WEST SUSSEX COUNTY COUNCIL CONSULTATION

TO:	Arun District Council FAO: Andrew Wood
FROM:	WSCC - Highways Authority
DATE:	25 September 2019
LOCATION:	Crete Nursery Dappers Lane Littlehampton BN16 4EN
SUBJECT:	A/104/19/RES Approval of reserved matters following A/178/17/OUT for the demolition of existing outbuildings with retention of existing dwelling & erection of 6 No. dwellings. Amendment received.
DATE OF SITE VISIT:	
RECOMMENDATION:	Advice
S106 CONTRIBUTION TOTAL:	N/A

Plan 1 – Construction Traffic Routes

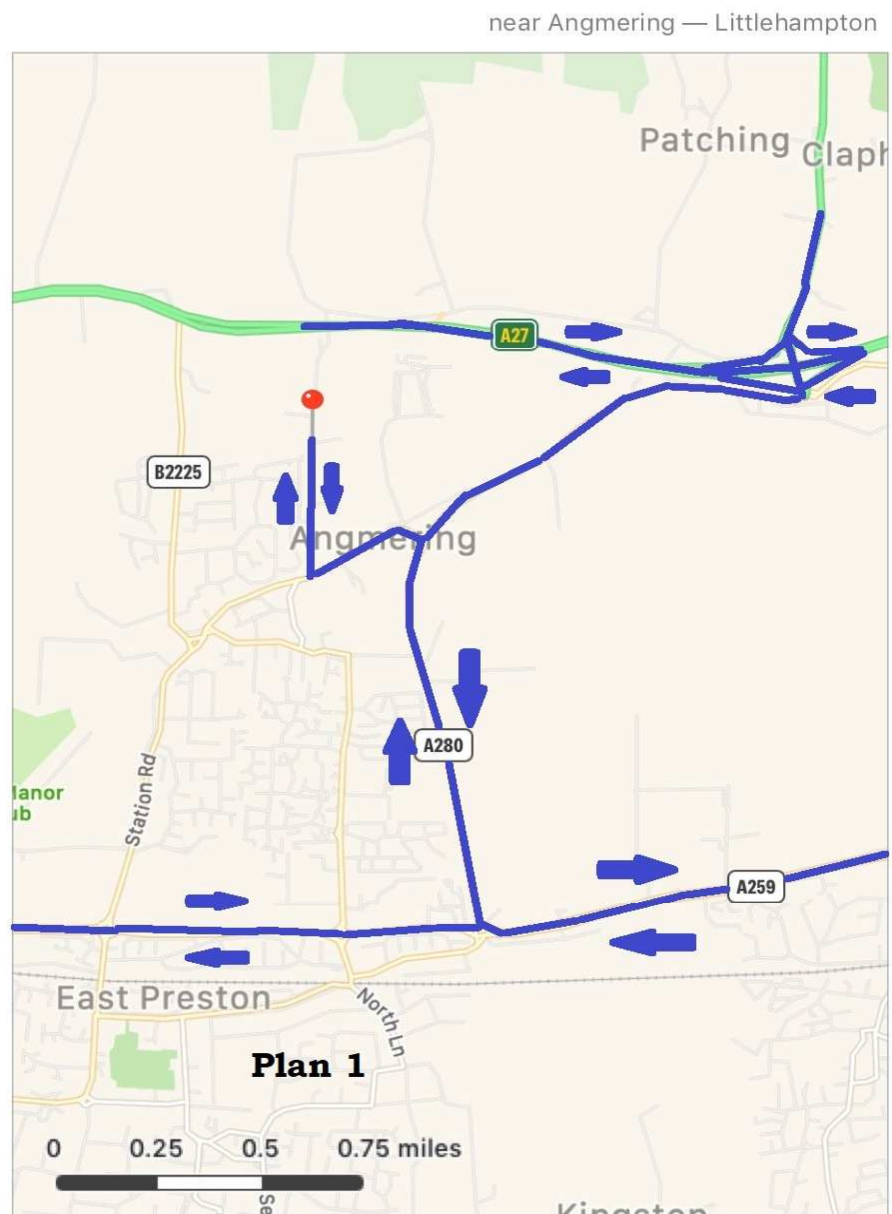
The CMP states that The access and egress of the site by both vehicles and personnel will be controlled and monitored at all times. Records of both will be kept demonstrating arrival, departure and nature of visit.

Sufficient space will be maintained within the site, to allow most vehicles to turn and drive out of the site. The LHA accept that as construction works progress, it may be necessary for these arrangements to be amended.

Based on the information submitted the LHA would be satisfied with the proposed CMP subject to the applicant adhering to the following:

- Schedule site deliveries outside times of peak traffic volume. This should be 08.00-09.00 am and 16.00 to 17.00.
- Ensuring that deliveries to site are kept to their allocated time slots.
- Avoid contractor parking in residential streets surrounding the site.
- Ensure that there are designated walkways on and around site.
